RFS

Your reference: SSD-71547218
Our reference: DA20240613002390-Response to
Submissions-1

**State Significant Development – Response to Submissions – Waste or resource management facility
1, 8 & 10 Styles Street & 145, 147 Mitchell Avenue Kurri Kurri NSW 2327, 3//DP586741, 1//DP1128108,
4//DP586741, 6//DP1251190, 1//DP1309128**

The NSW Rural Fire Service (RFS) has reviewed the *Kurri Kurri Integrated Resource Recovery Centre Response to Submissions Report* (Central Waste Plant Pty Ltd), prepared by EMM Consulting Pty Ltd (Alexandra Bishop, March 2026), including Appendix F (Report titled: *Updated Bushfire Consultant Response to RFS Submission*, prepared by Cool Burn Pty Ltd. Ref J317, dated 16 March 2026).

Weighbridge Shed - 1st / 2nd Floor Plan  
Scale: 1 : 100

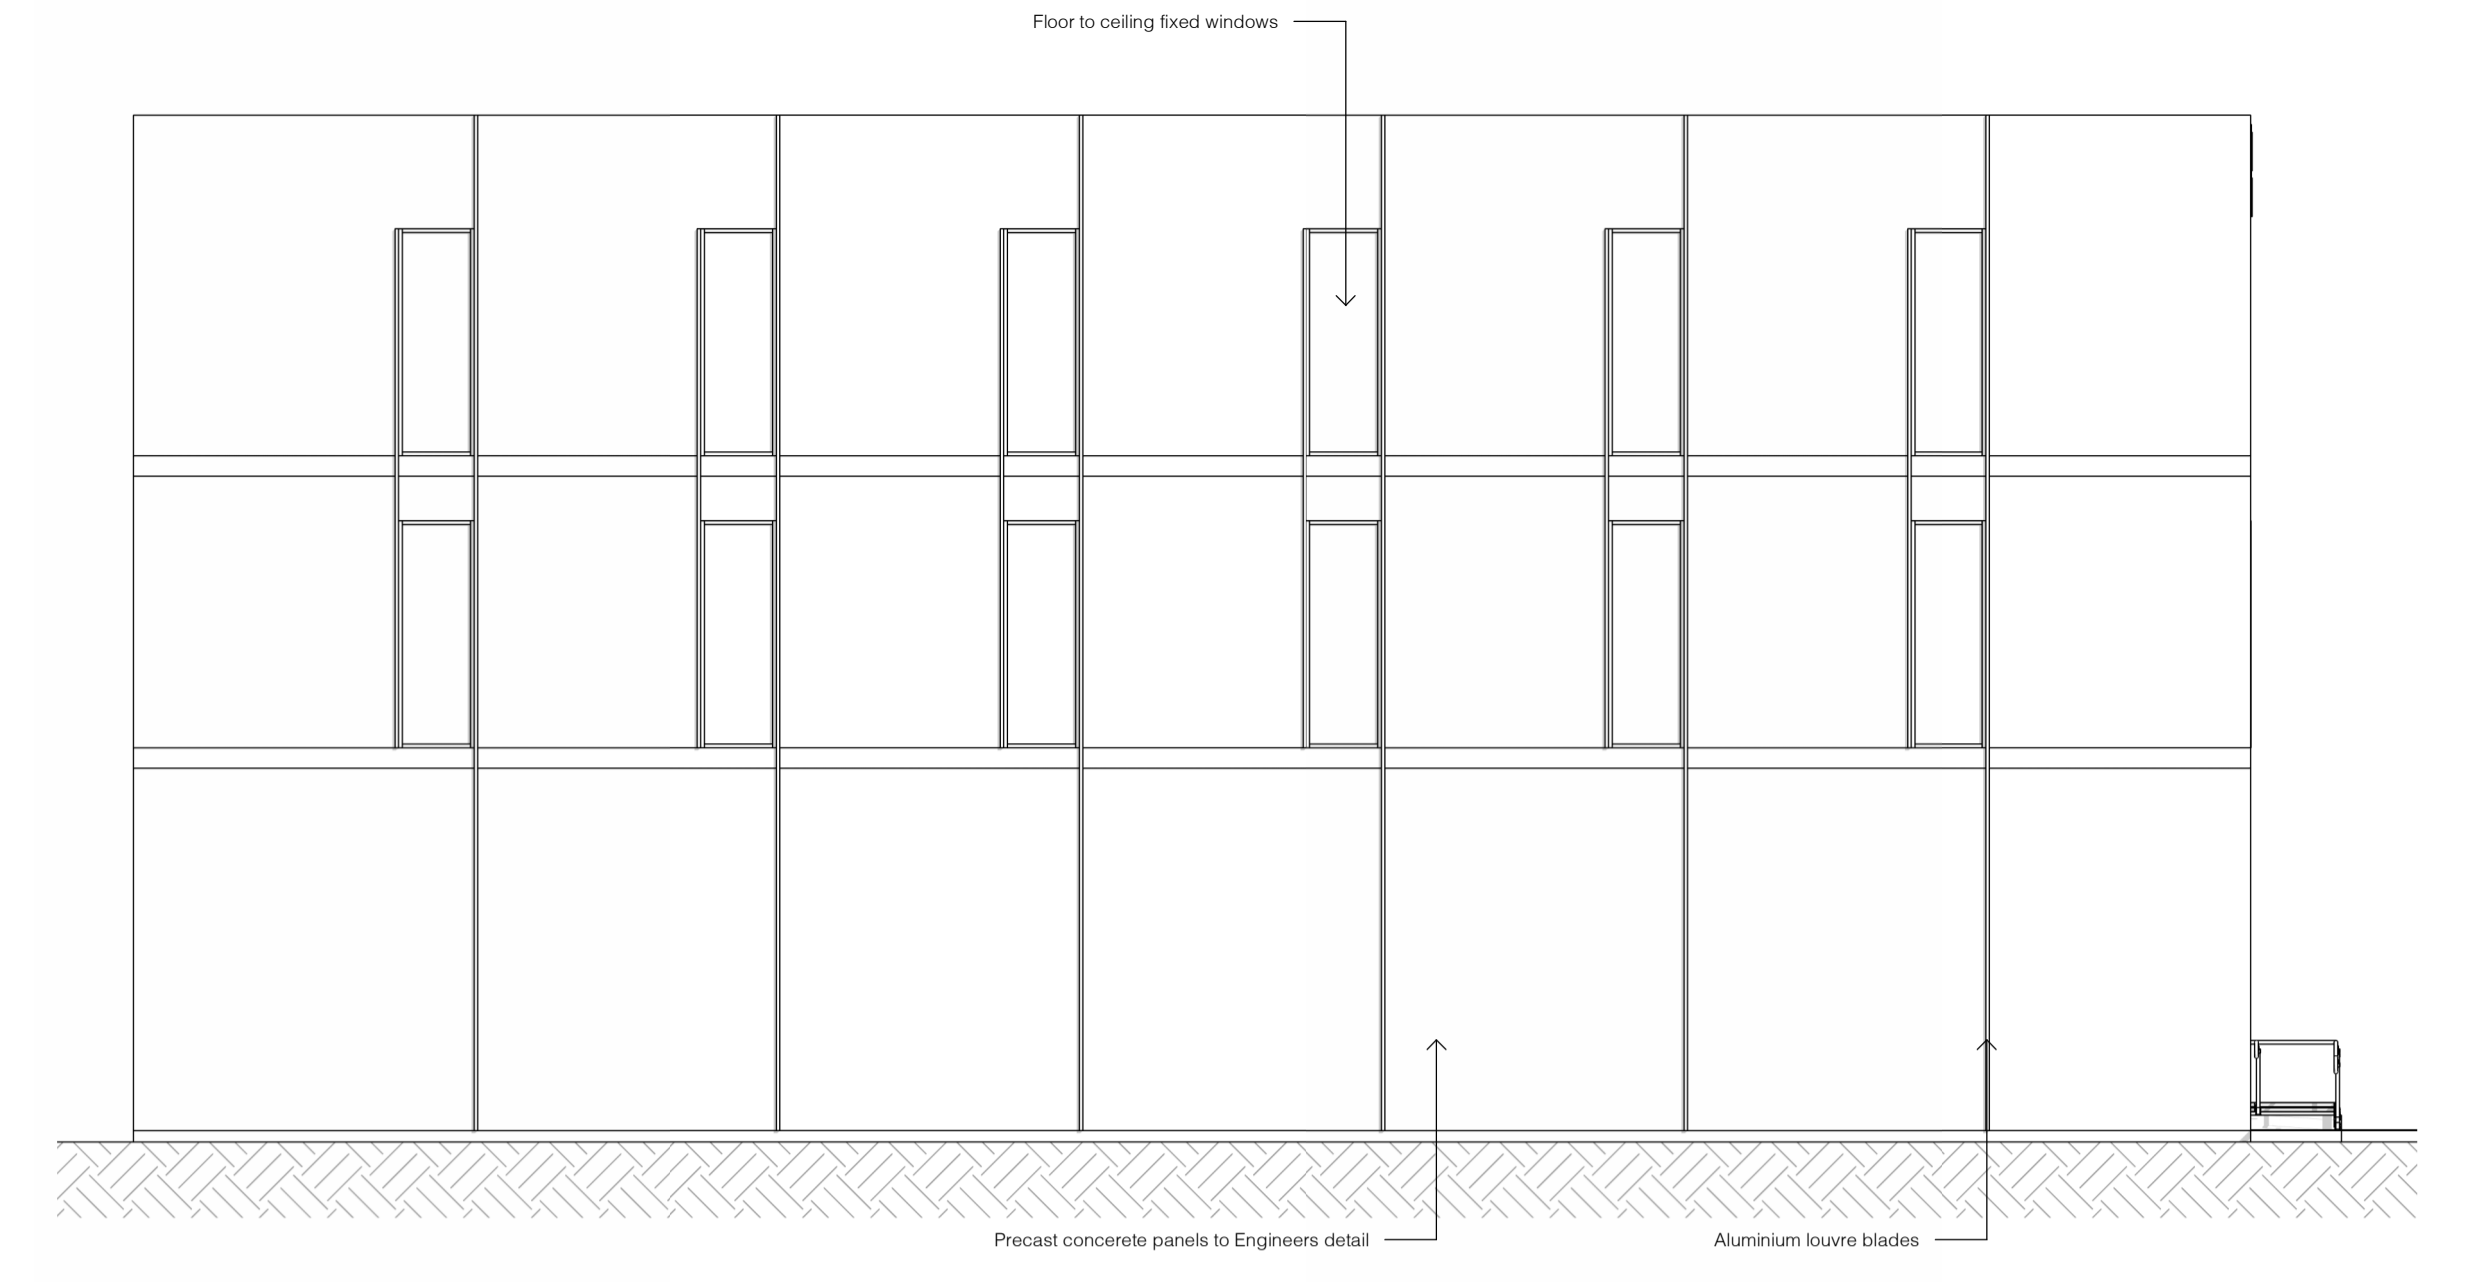
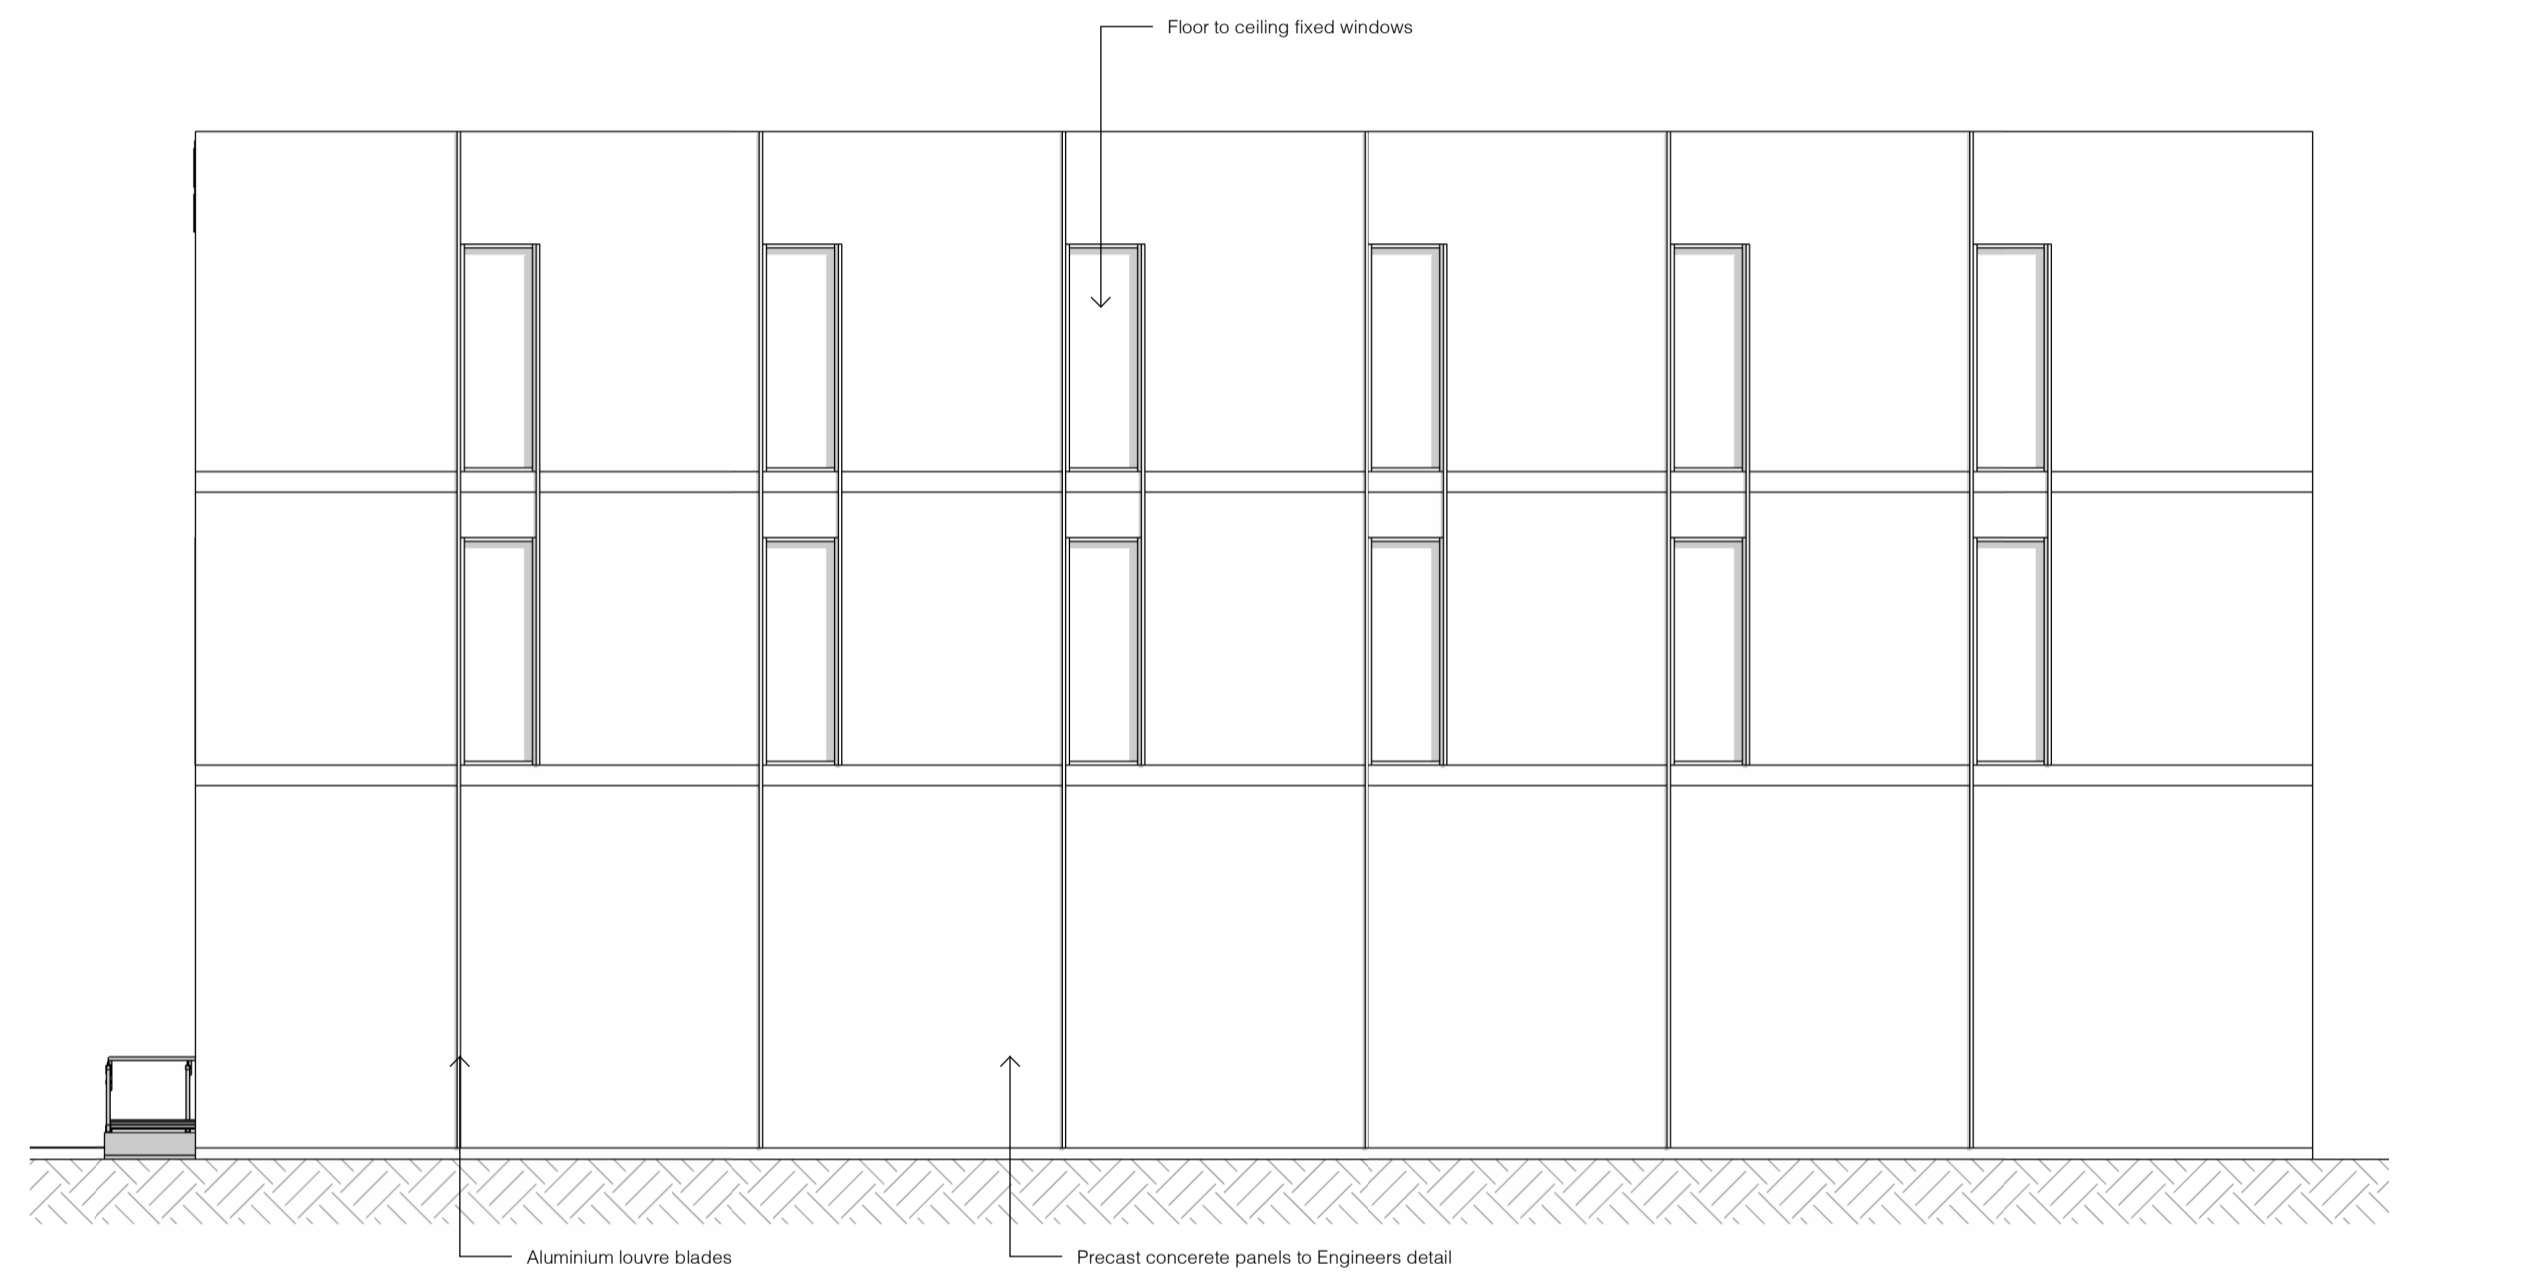
4. The proposed offices located above the weighbridge, must be upgraded to improve ember protection by enclosing all openings (excluding roof tile spaces) or covering openings with a non-corrosive metal screen mesh with a maximum aperture of 2mm. Where applicable, this includes any sub floor areas, openable windows, vents, weepholes and eaves. External doors are to be fitted with draft excluders.
